**From:** [Downes, Scott G \(DFW\)](#)  
**To:** [Jeremiah Cromie](#)  
**Subject:** RE: mit plan  
**Date:** Tuesday, June 20, 2023 8:07:06 AM

Please see the latest revised mitigation plan for the Kostanich Reasonable Use application. This is the one that is next to Silver Fir that we visited about 2 weeks ago. Let me know if you have any further comments.

Attached is the revised mitigation plan from Ed based on Scott's recent comments after visiting the site. This is in regards to Project RU-22-0005 Kostanich.

MITIGATION SITE PLAN, NOTES, & DETAILS

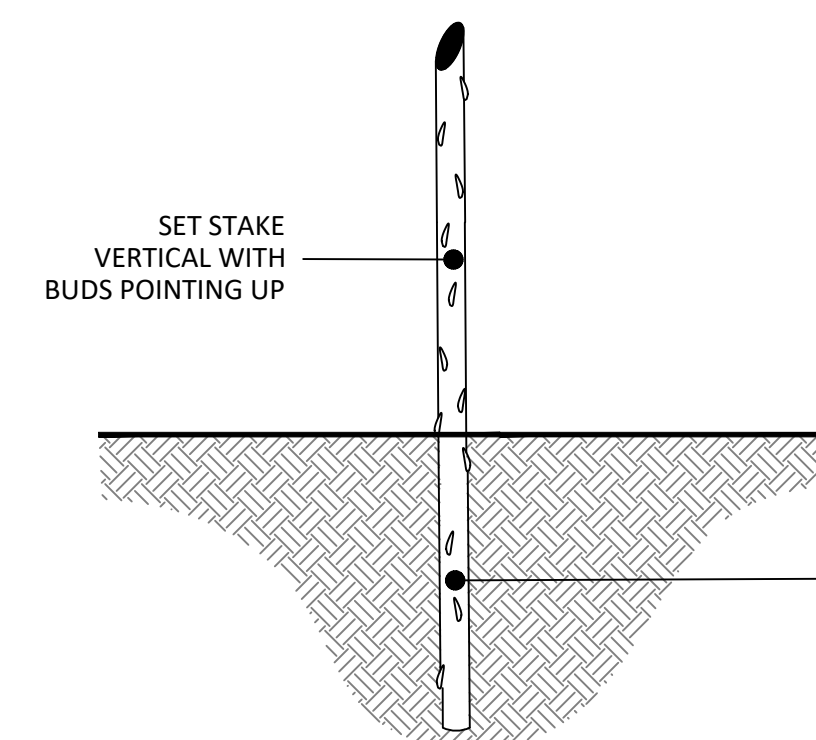
Jeremiah,  
Looks good to me. I assume we are putting a condition in that we discussed of no tree removal within 50'? If yes, WDFW is good with things.
